**Application Reference:** 2025/0814

**Site Address:** 10 Tivy Dale Close, Cawthorne, Barnsley, S75 4ER

**Introduction:** This application seeks full planning permission for a 2 storey side extension (including conversion of existing integrated garage to habitable space), erection of detached garage, alterations to landscaping to front and removal of side door and window to dwelling

Title
Proposed Plans - Option 3

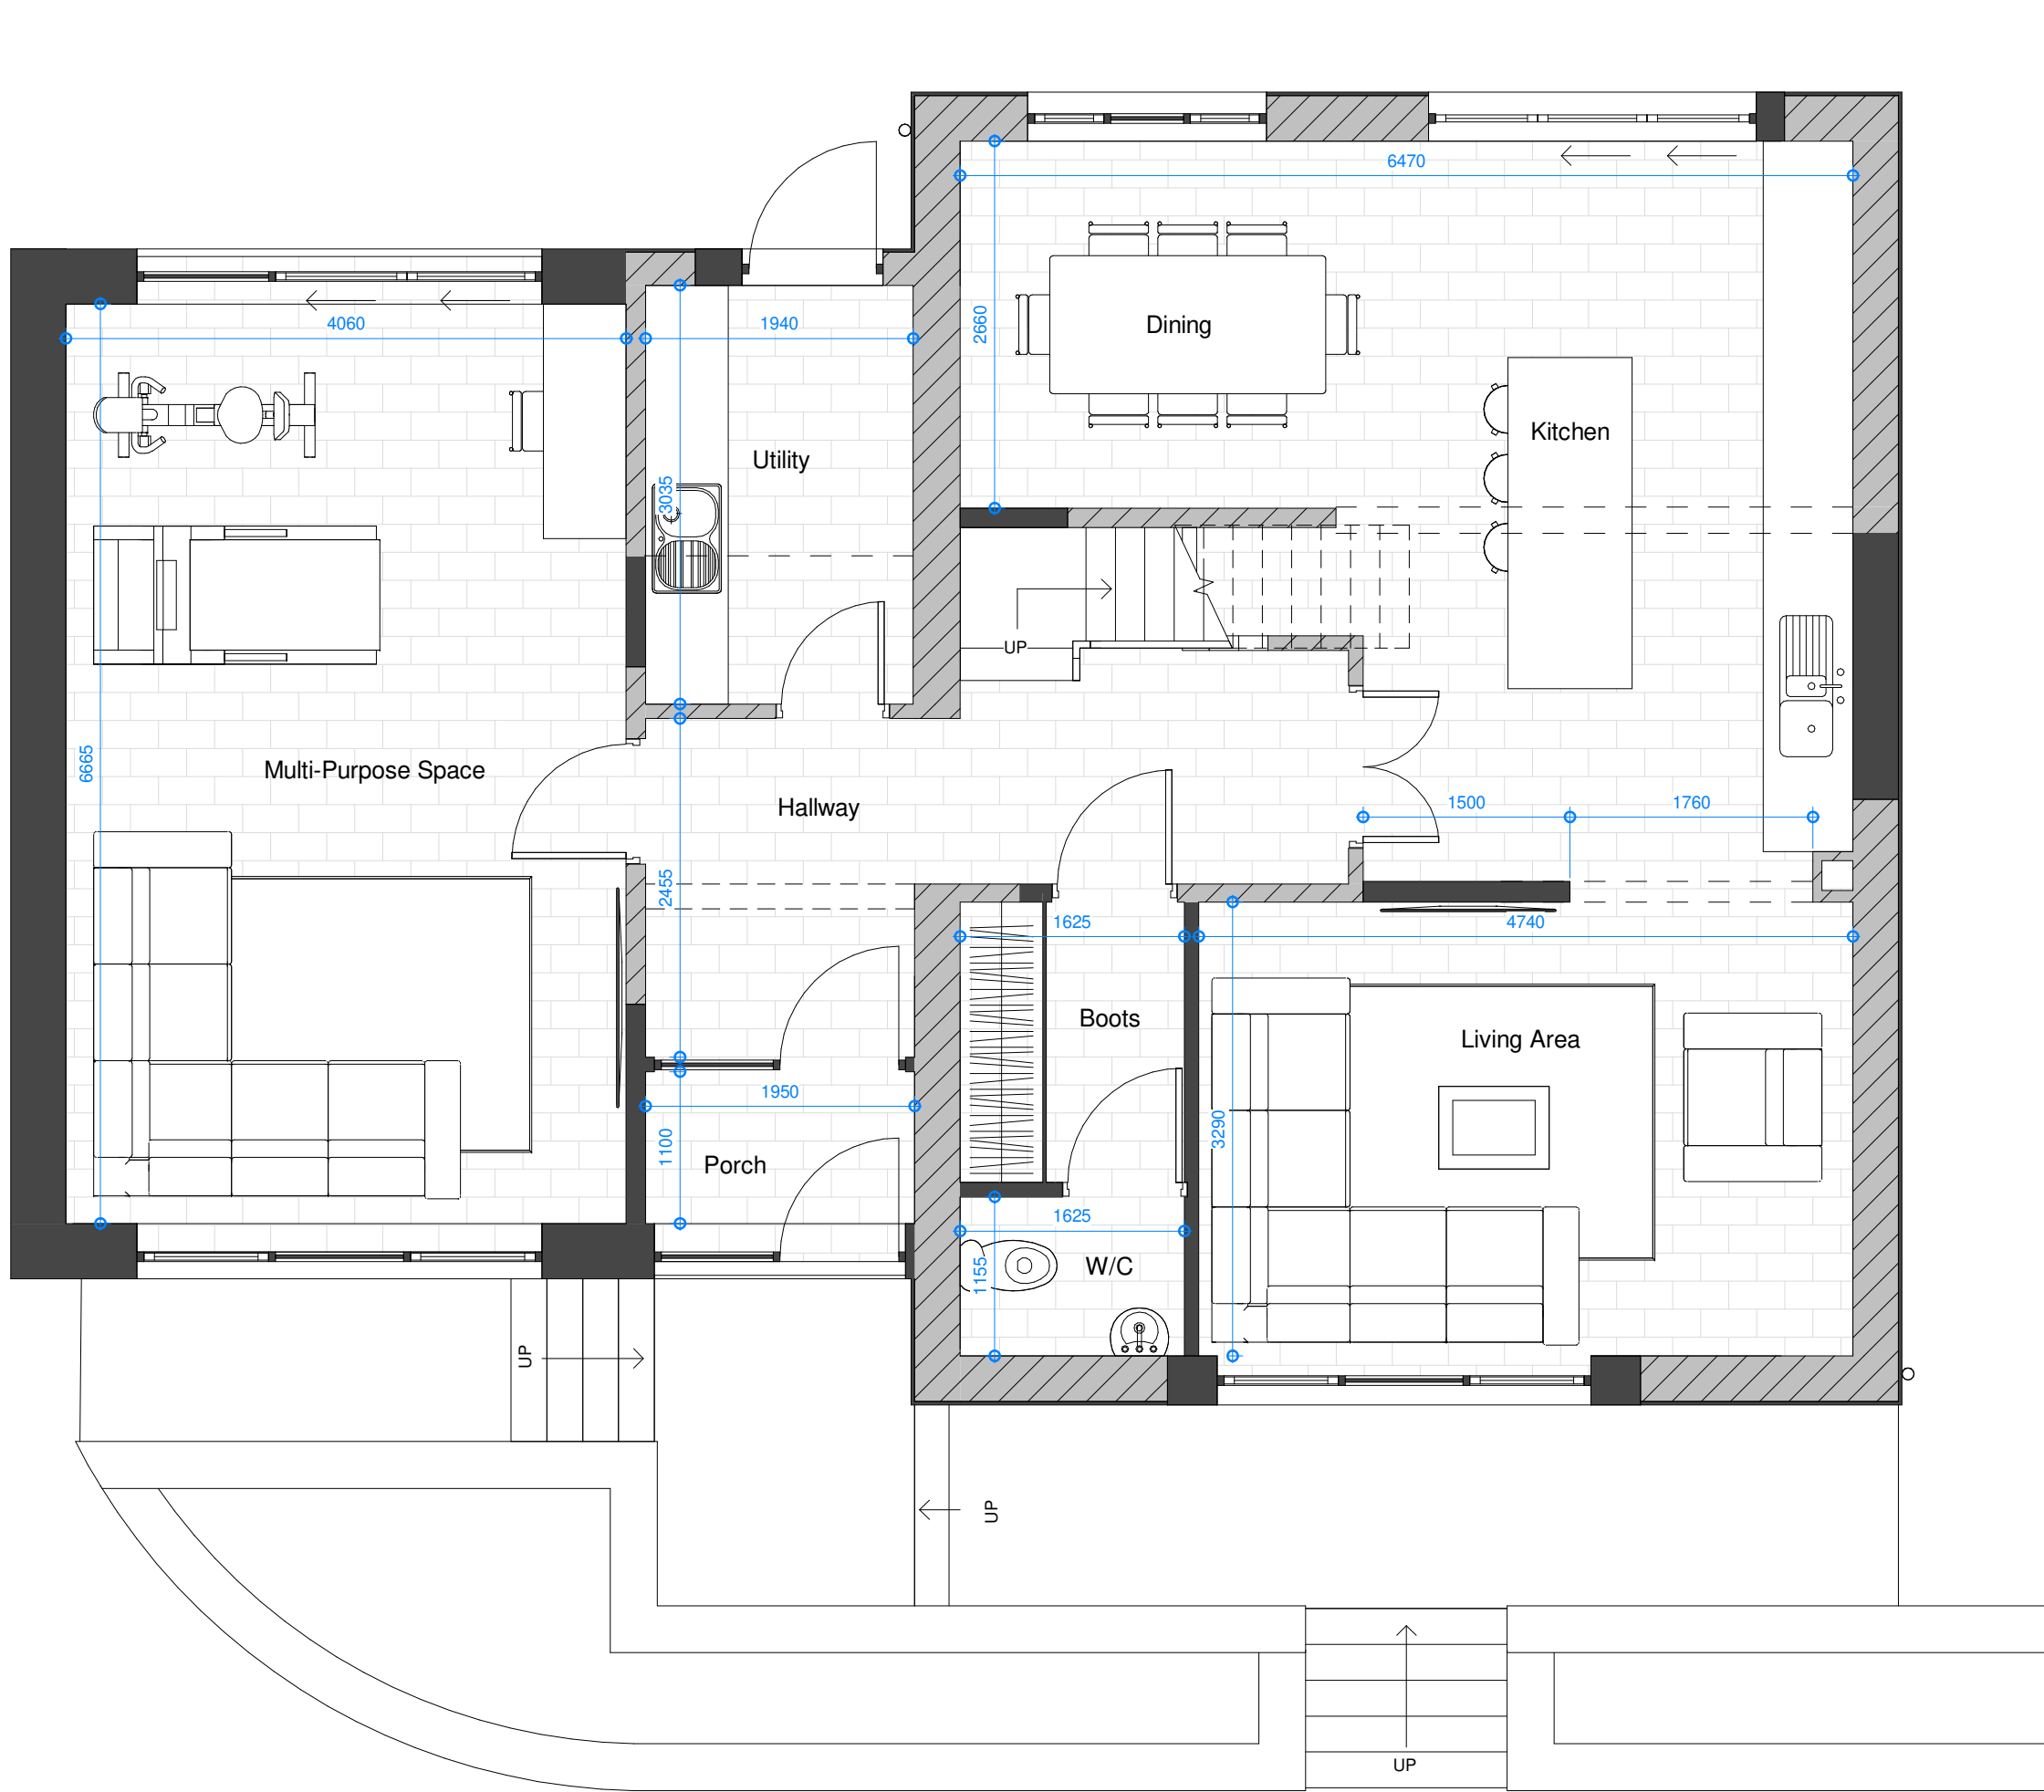
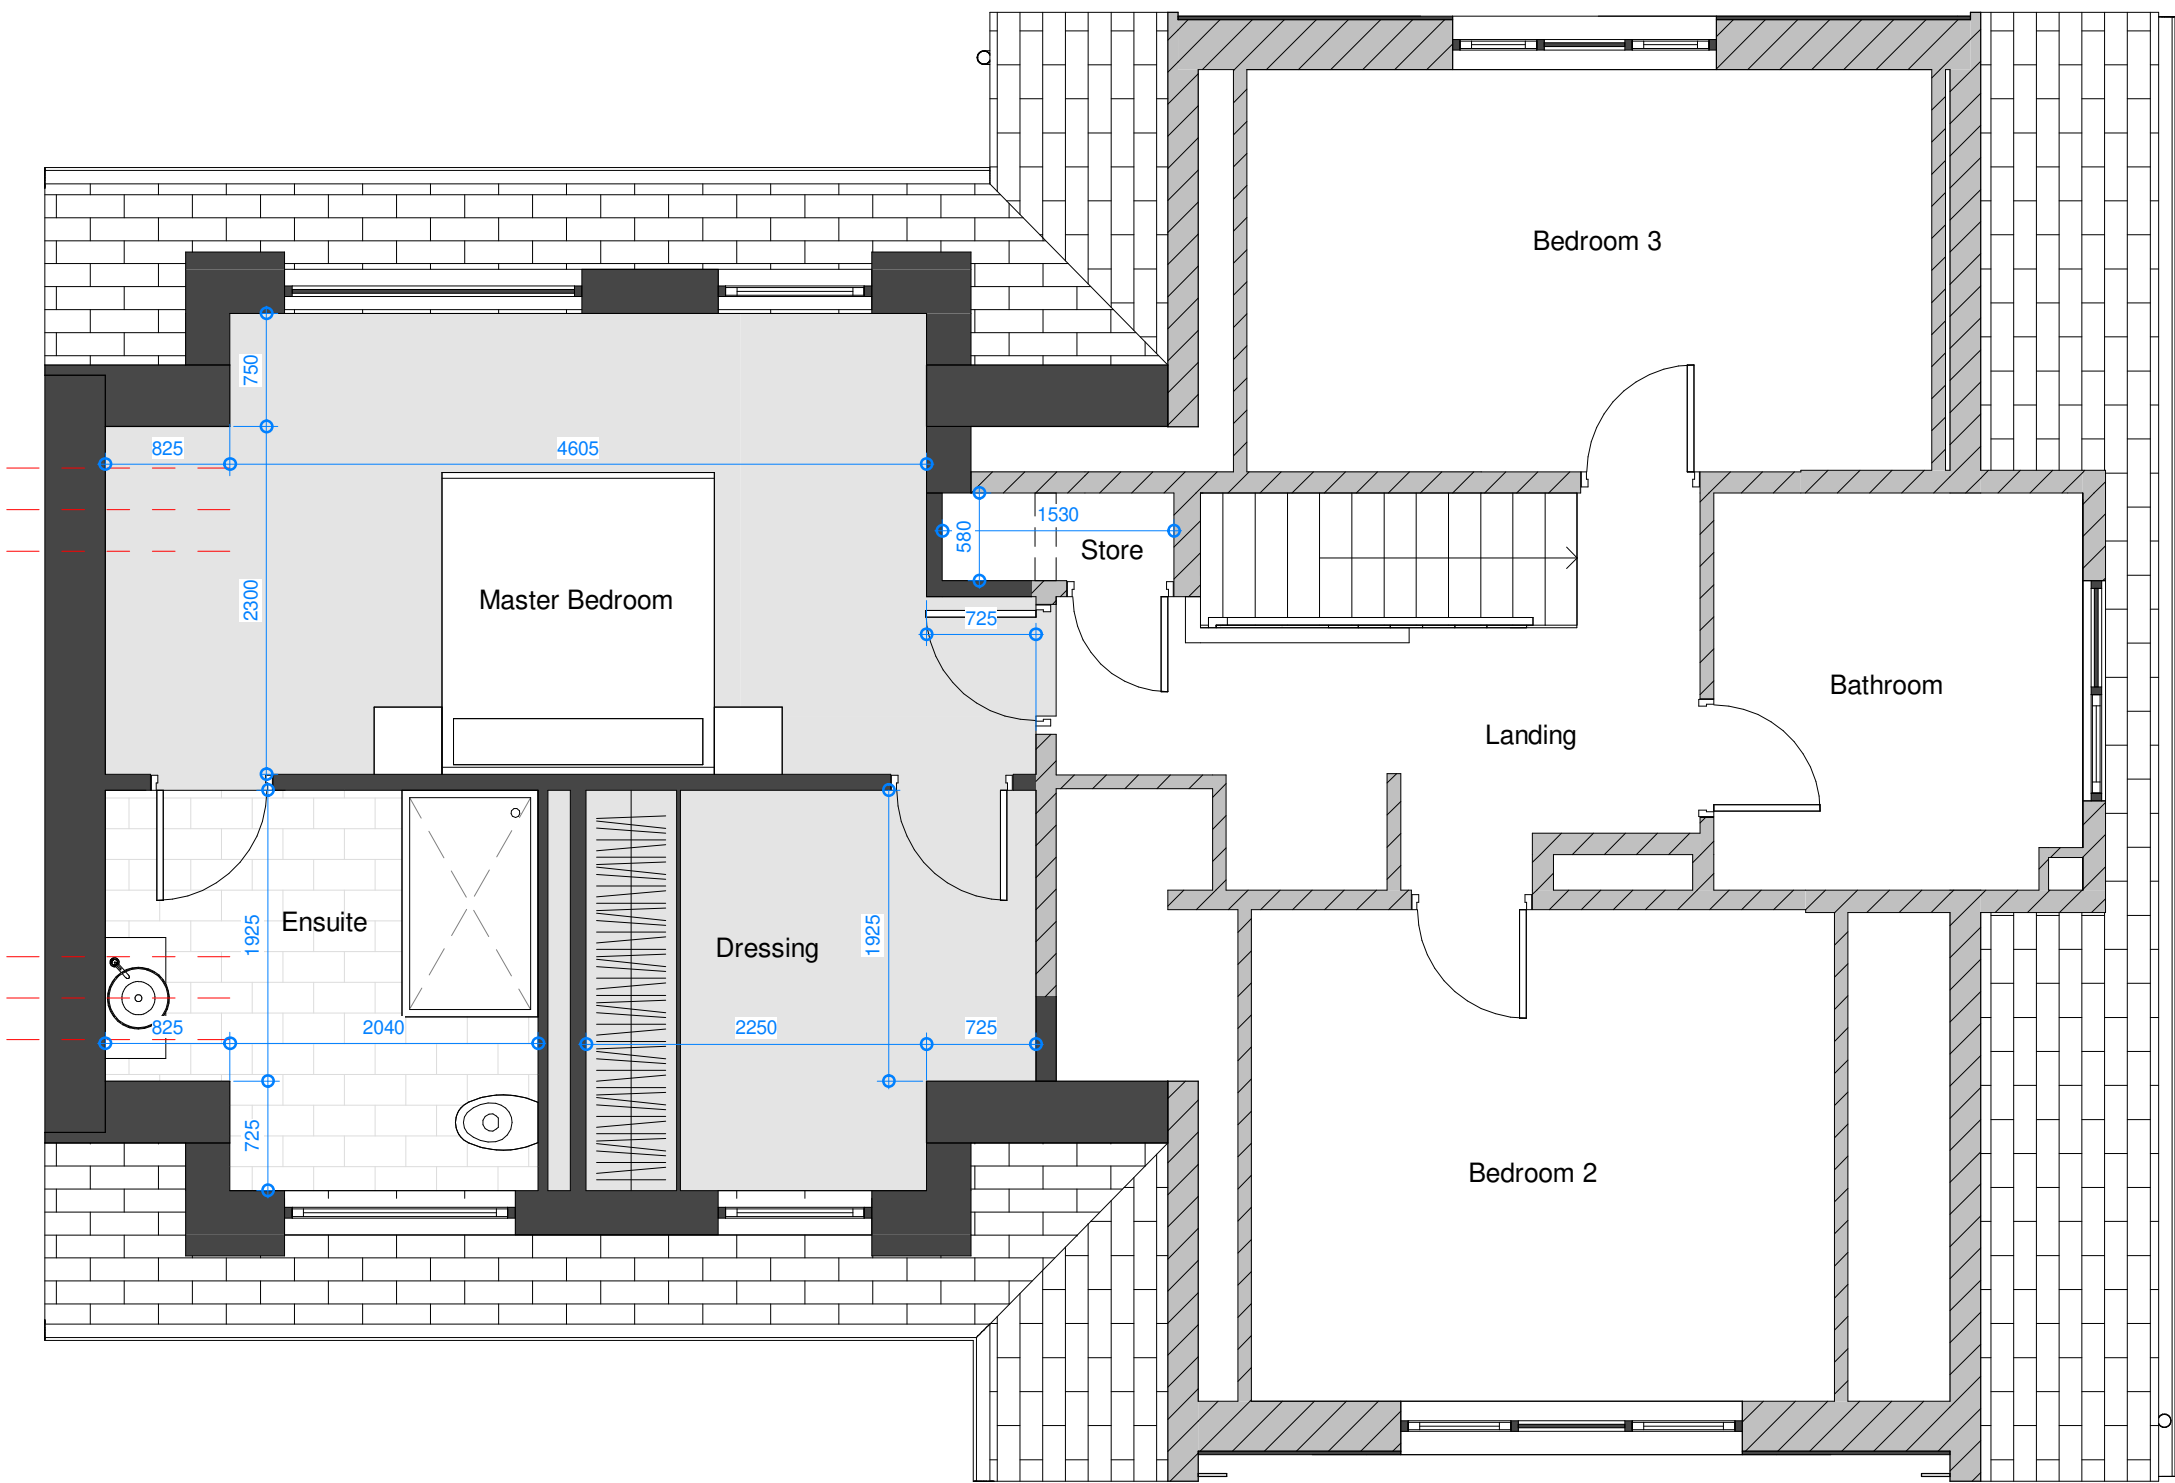
The proposed extension would wrap around the existing set back aspect of the dwelling's front elevation, which includes the integrated garage and front entrance door, both sat below the existing front dormer. The front projection of the extension is approximately 2.1m, with a side projection of 6.53, although from the existing side elevation of the garage, is reduced to just 1.4m. As a set back from the front elevation is maintained, along with an approximate 21sqm footprint for the whole extension; compared to the approximate 95sqm footprint of the current dwelling, it would be considered as a modest sized extension, and as noted above would not cause significant harm to the scale of the dwelling.

As the dwelling occupies what is essentially a corner plot, extra restrictions are imposed by the House Extension and Domestic Alterations SPD, requiring side extension be no larger than two-thirds the width of the original dwelling or 50% of the distance between the dwelling and side boundary, whichever is the shortest measurement. With an existing, approximate house width measurement of 12.27m, and a side elevation to boundary measurements of 7.36m equating to a potential maximum side projection of 3.8m (50% of distance), the 1.4m extension would be within SPD guidance.
